Our Case Number: ABP-317660-23

Re: Busconnects Kimmage to city centre core bus corridor scheme
Kimmage, Dublin

KIMMAGE TO CITY CENTRE CORE BUS CORRIDOR SCHEMELANDSCAPING AND URBAN REALM

Programme Title BUSCONNECTS DUBLIN CORE BUS CORRIDORS INFRASTRUCTURE WORKS				
Drawing Title KIMMAGE TO CITY CENTRE CORE BUS CORRIDOR SCHEME LANDSCAPING AND URBAN REALM				
Drawing File Name BCIDD-ROT-ENV_LA-0011_ML_00-DR-LL-0004	Sheet Number 04 of 14	Status A	Rev M01

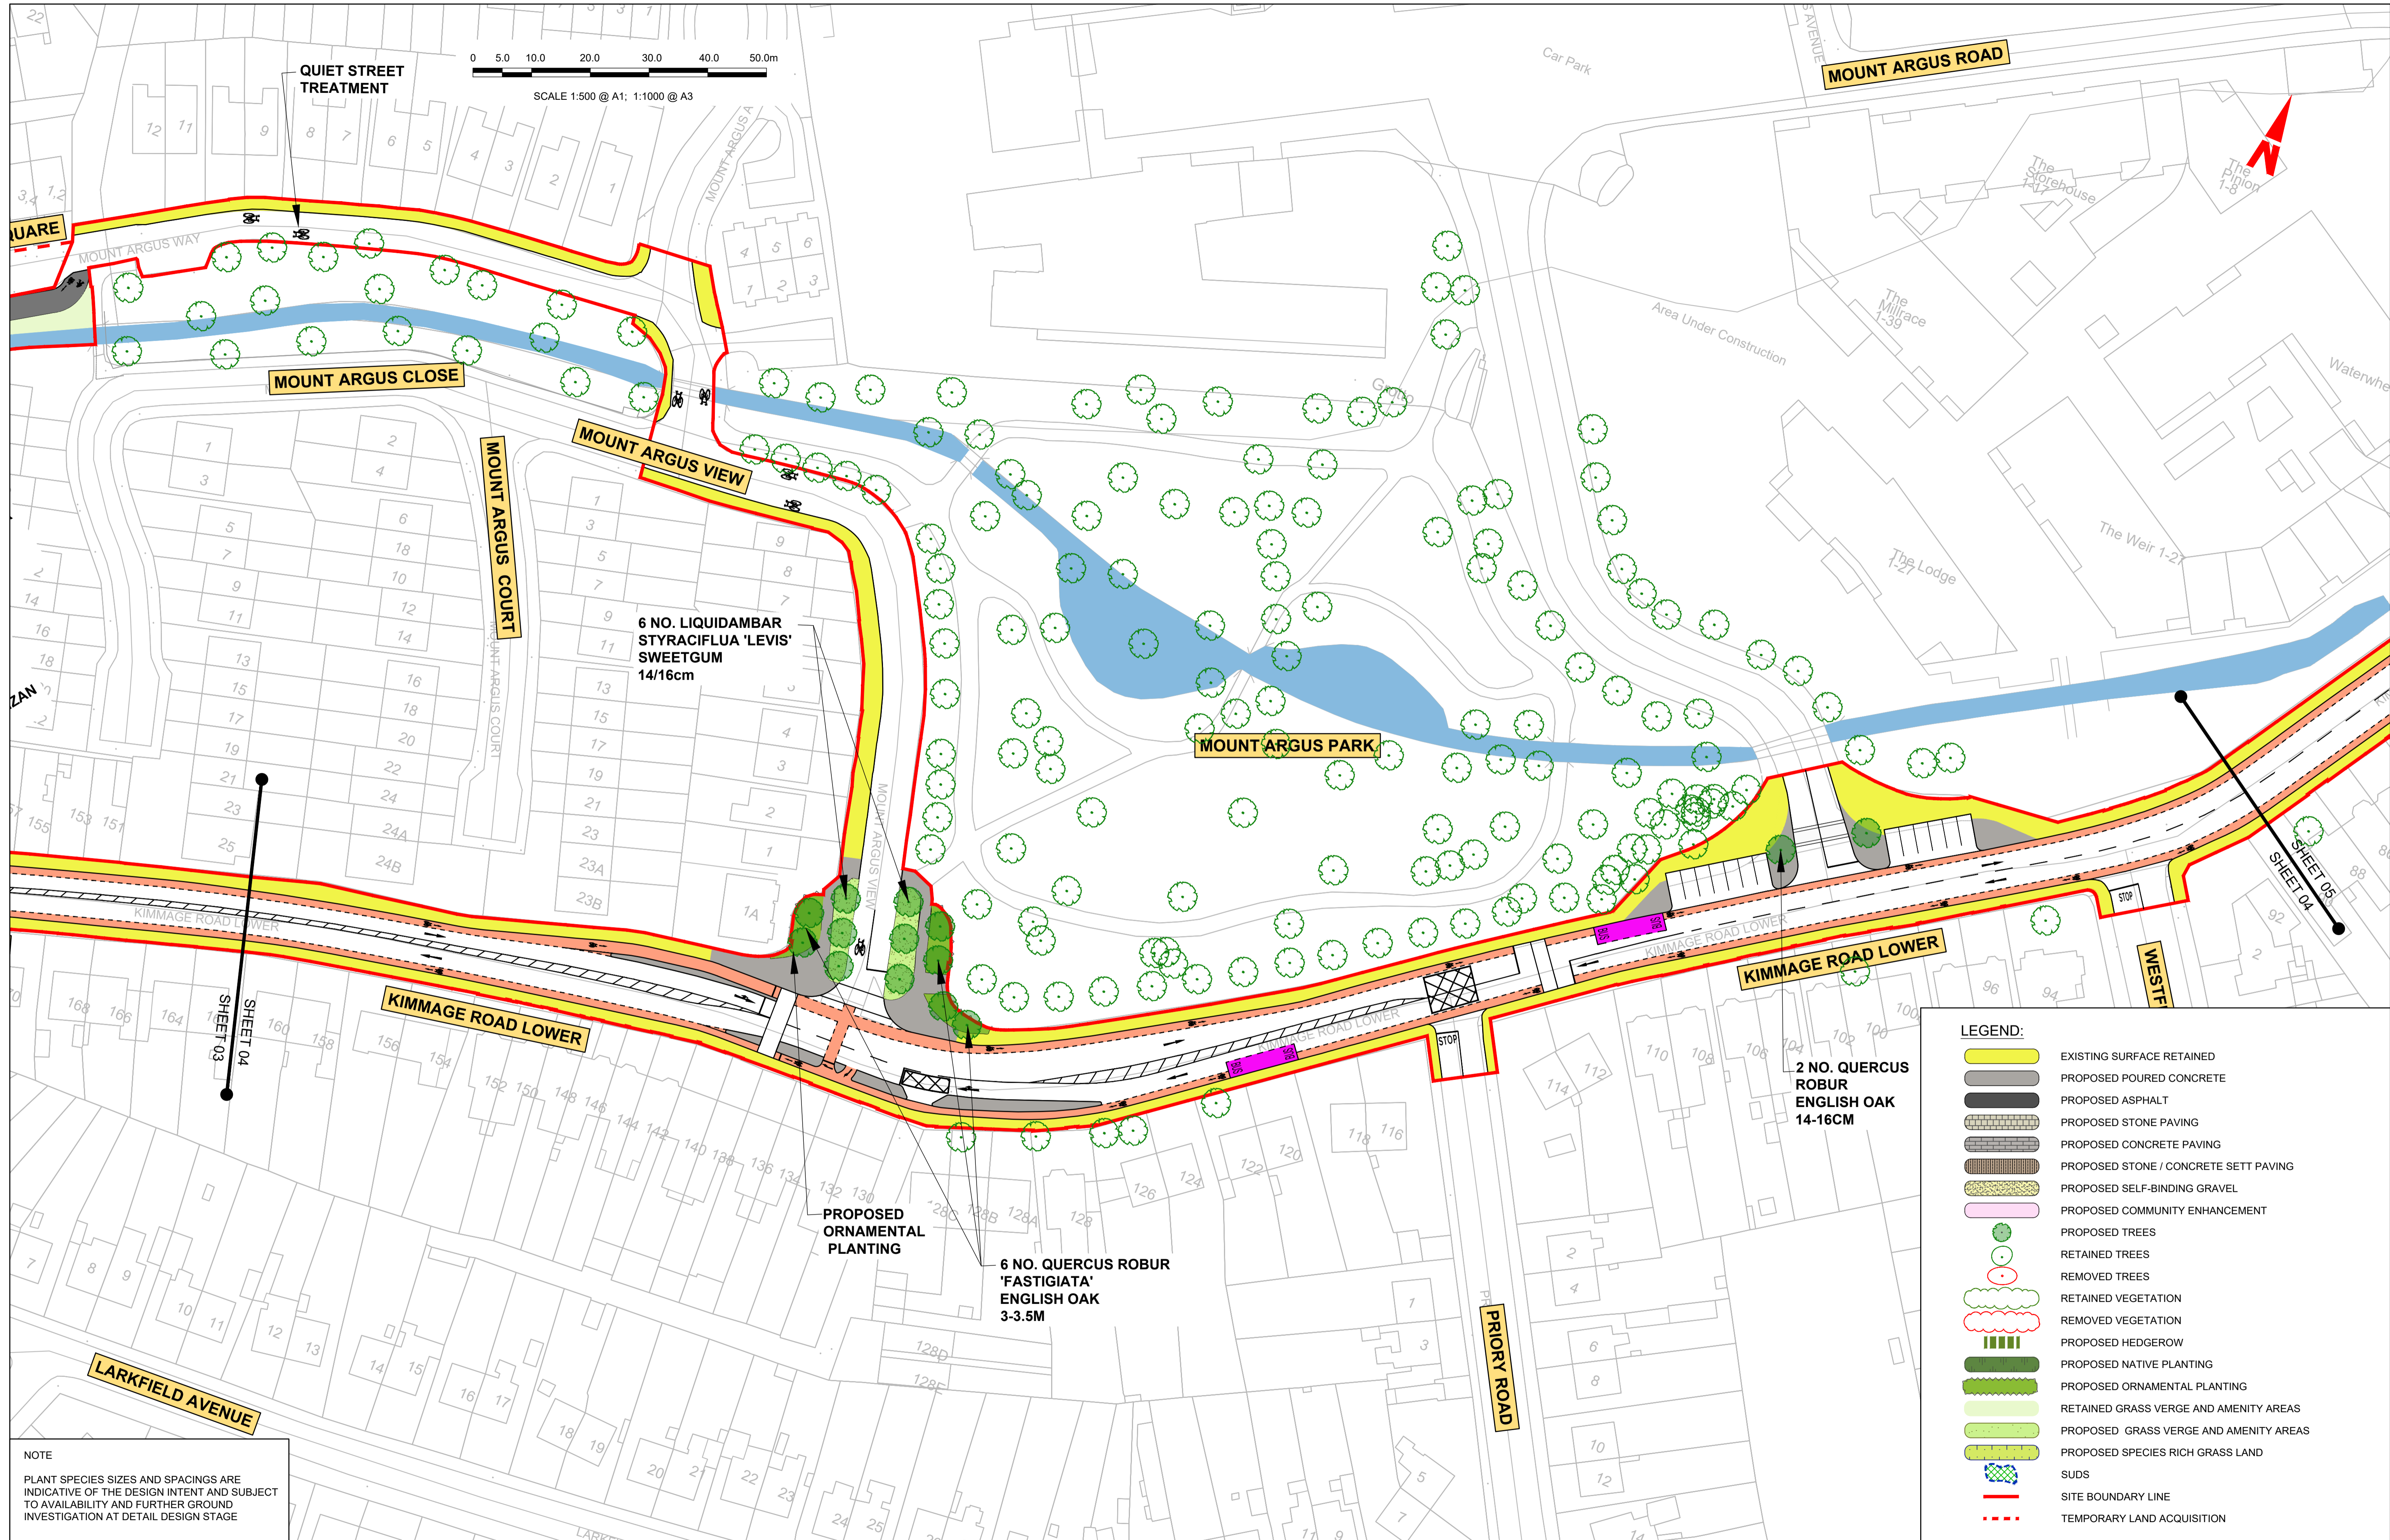
There are existing telephone / light / sign poles which are poorly located which prevent two way walking traffic due to minimum distance between poles & boundary wall to the footpath. The concrete foot paths have been shown as yellow indicating no amendment to locations. This poles should be repositioned while the works are underway. These poles should be repositioned while the

improvement works are underway. Suggest survey carried out to determine locations to full layout (sheet 1 – 14) and correct amend within layouts. See below photo for example.

Drawing File Name	Sheet Number	Status	Rev																																																
BCIDD-ROT-ENV_LA-0011_ML_00-DR-LL-0005	05 of 14	A	M01

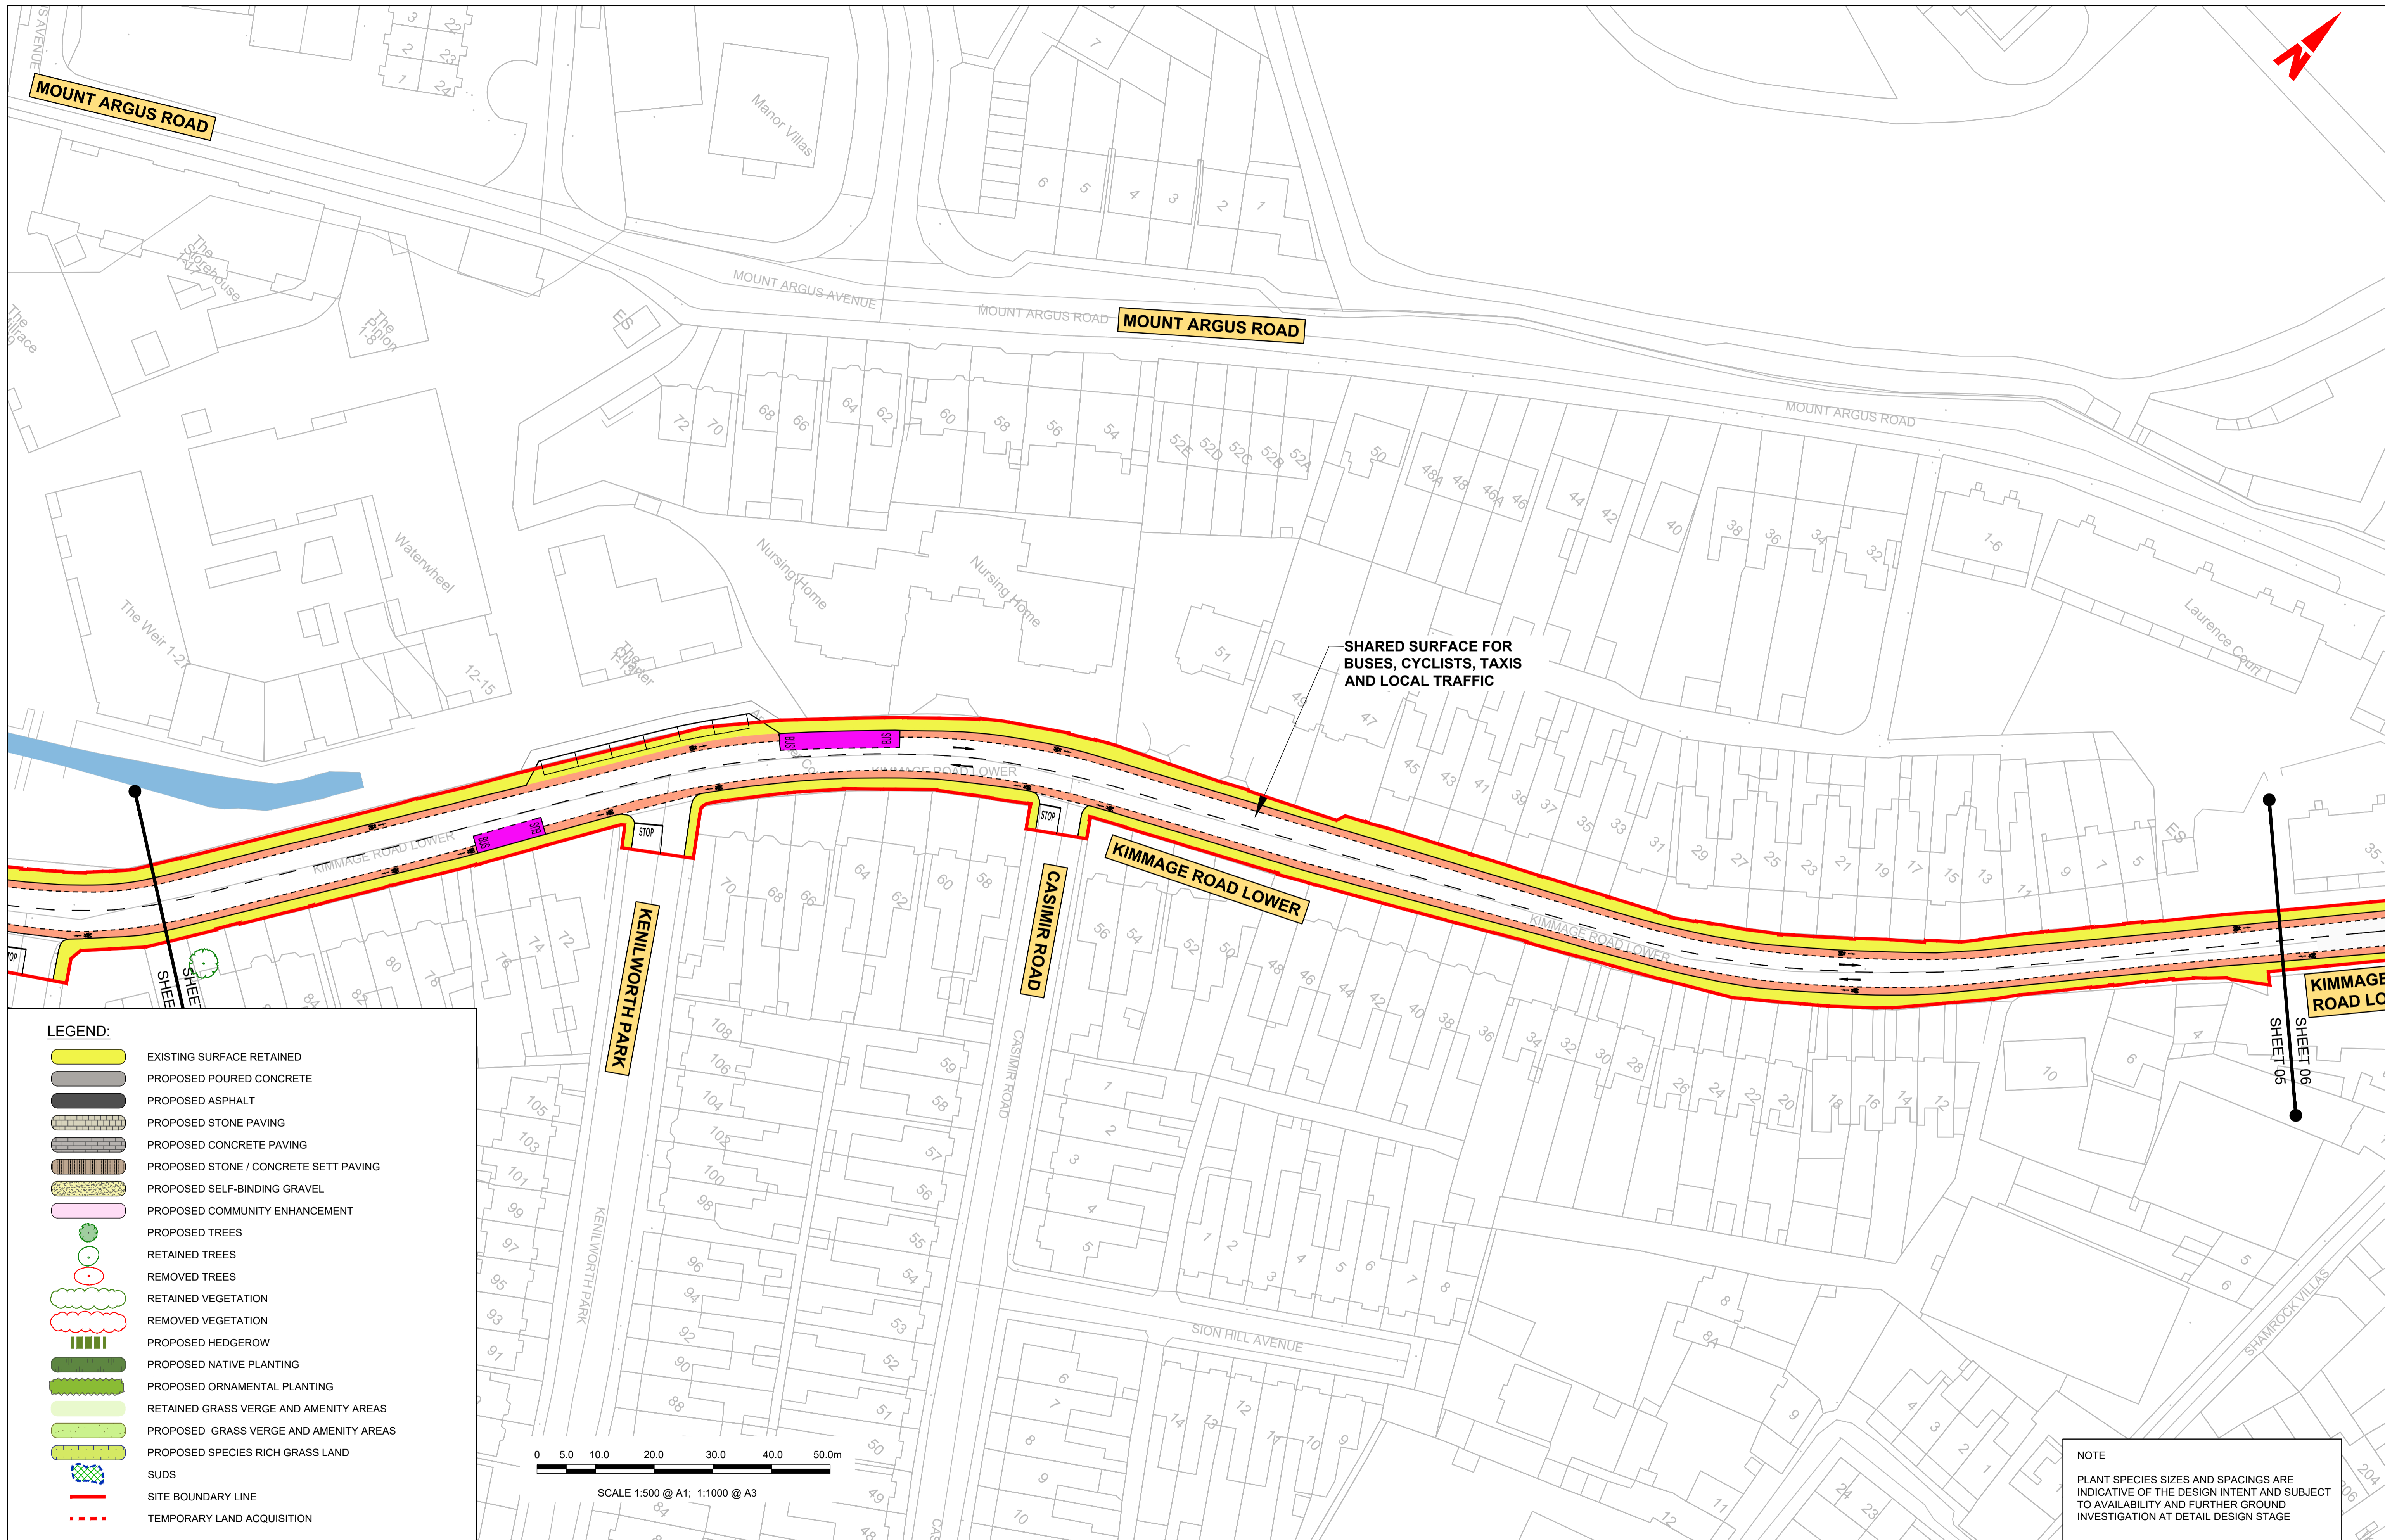
There are existing telephone / light / sign poles which are poorly located which prevent two way walking traffic due to minimum distance between poles & boundary wall to the footpath. Suggest survey carried out to determine locations to full layout (sheet 1 – 14) and correct amend within layouts.

Programme Title BUSCONNECTS DUBLIN CORE BUS CORRIDORS INFRASTRUCTURE WORKS			
Drawing Title KIMMAGE TO CITY CENTRE CORE BUS CORRIDOR SCHEME LANDSCAPING AND URBAN REALM			
Drawing File Name BCIDD-ROT-ENV_LA-0011_ML_00-DR-LL-0006	Sheet Number 06 of 14	Status A	Rev M01

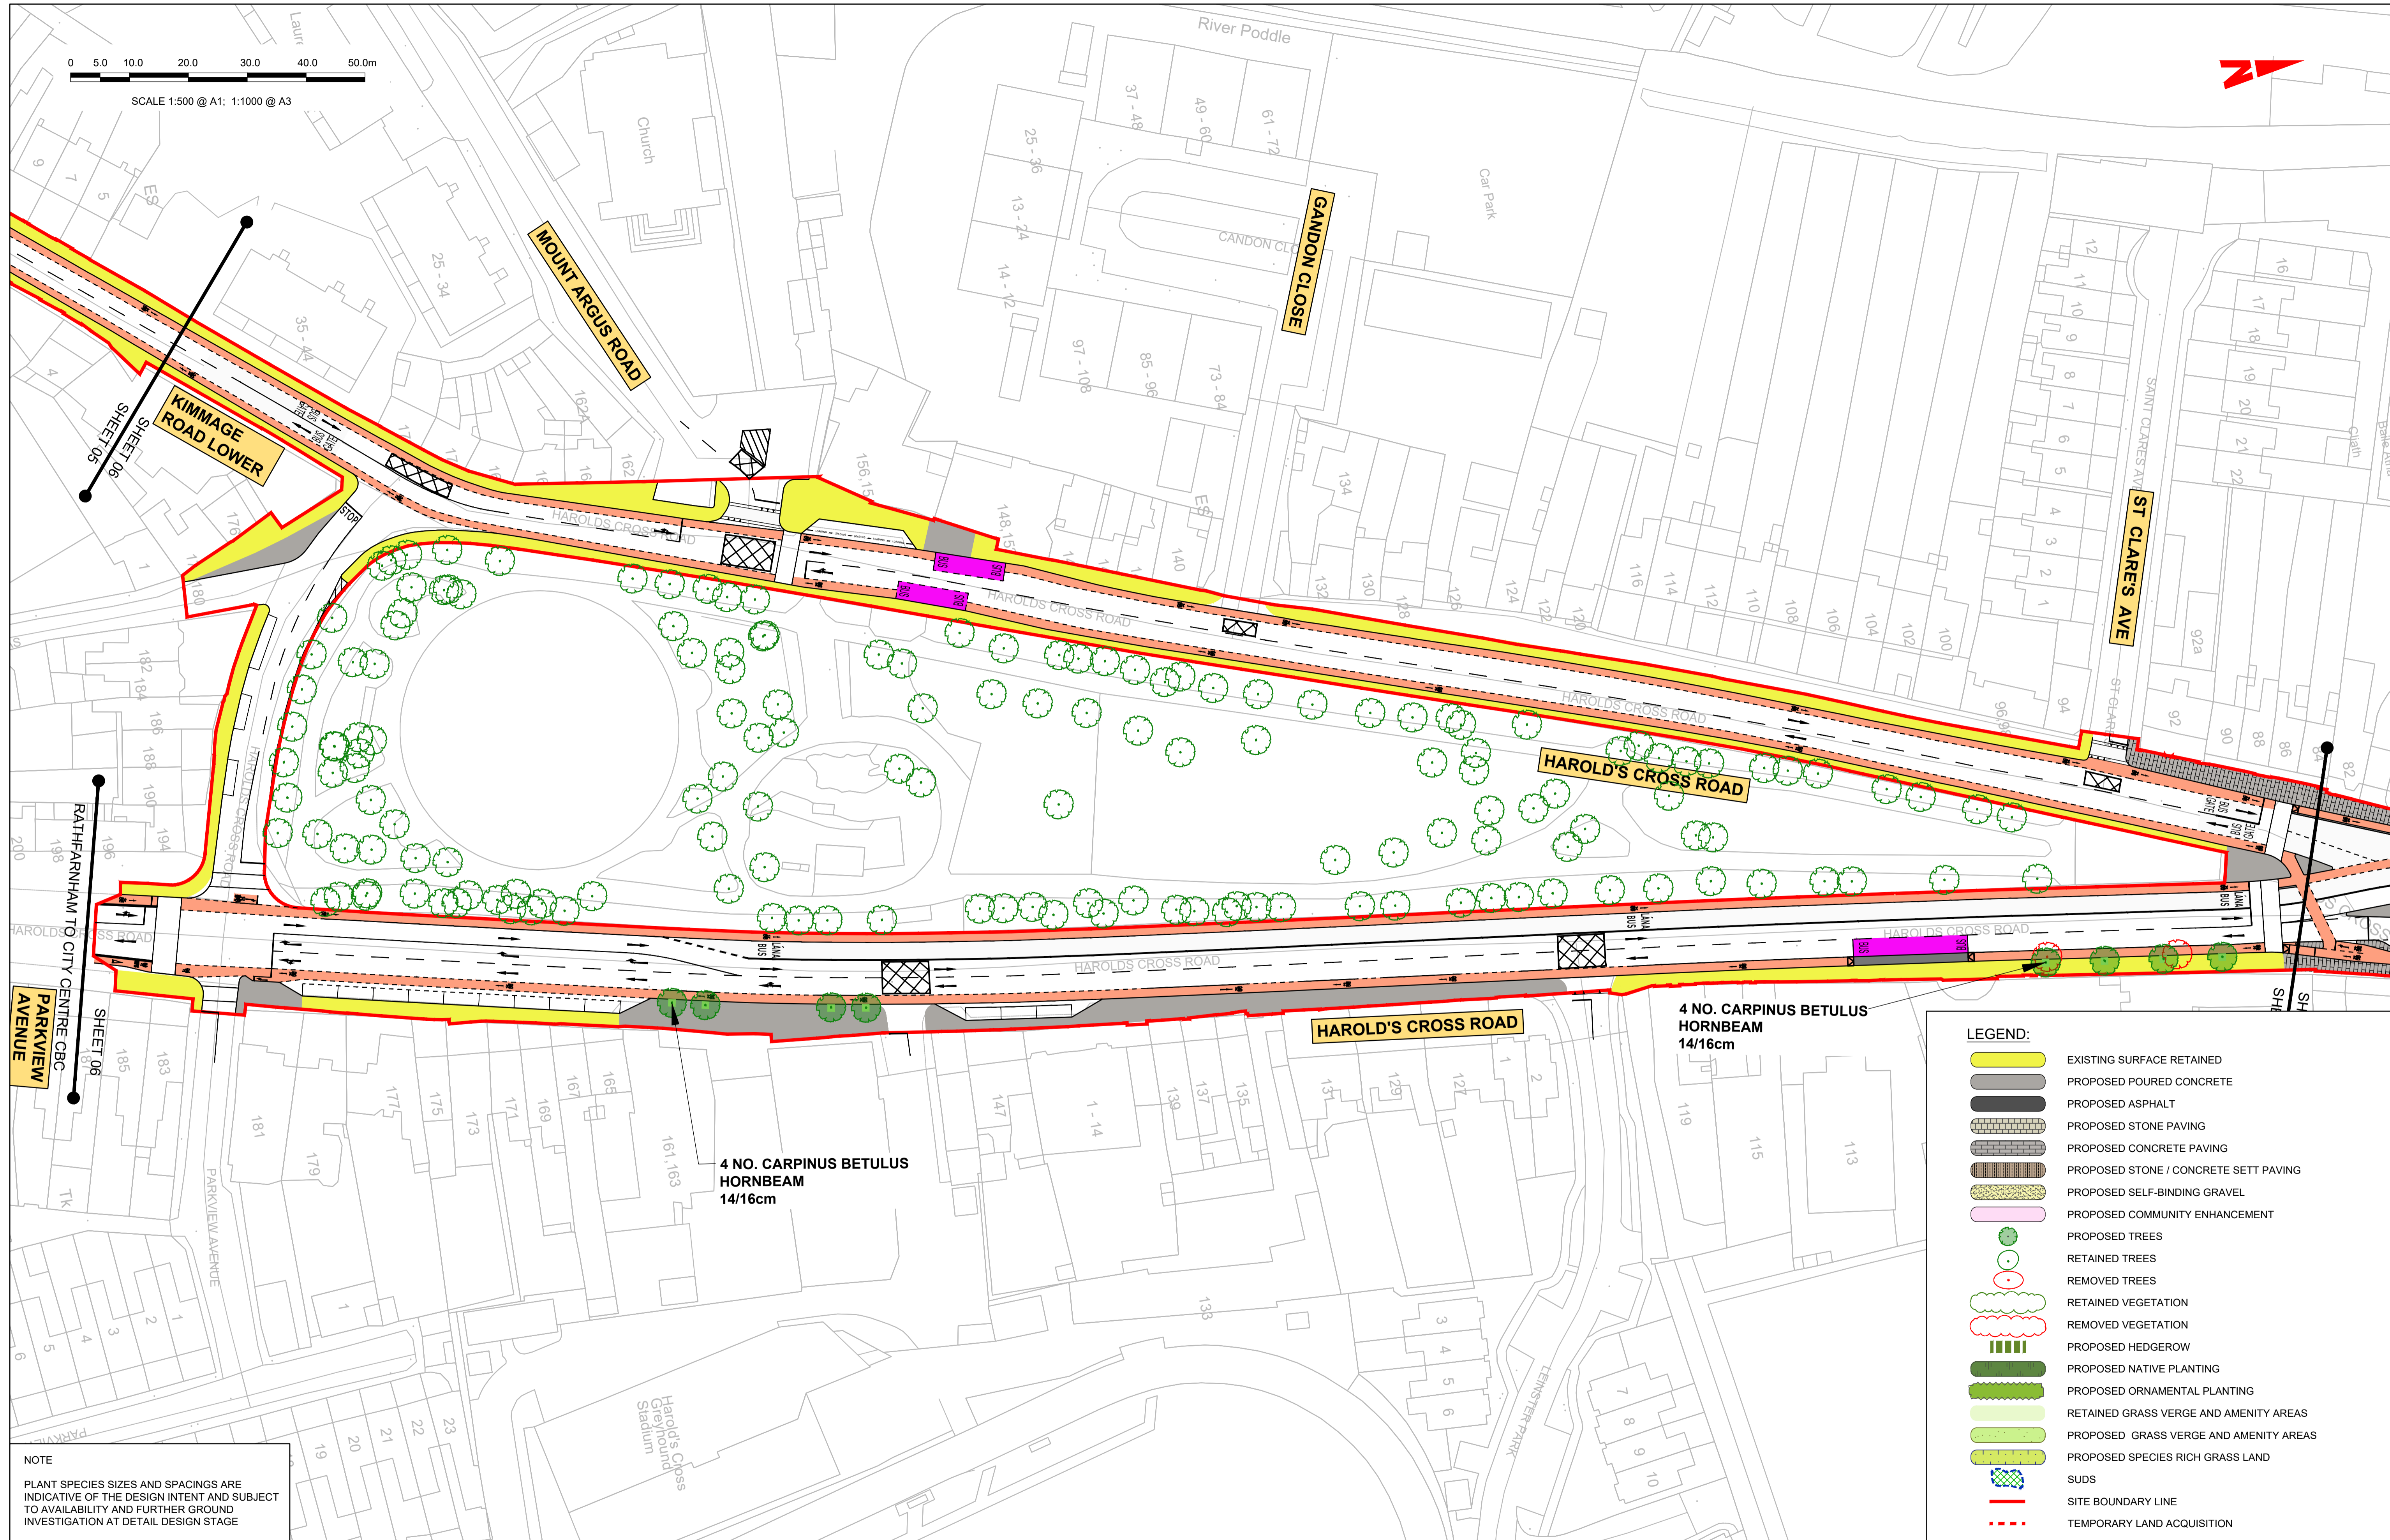
As above, granite paving and more ambitious public landscaping / street furniture should be provided.
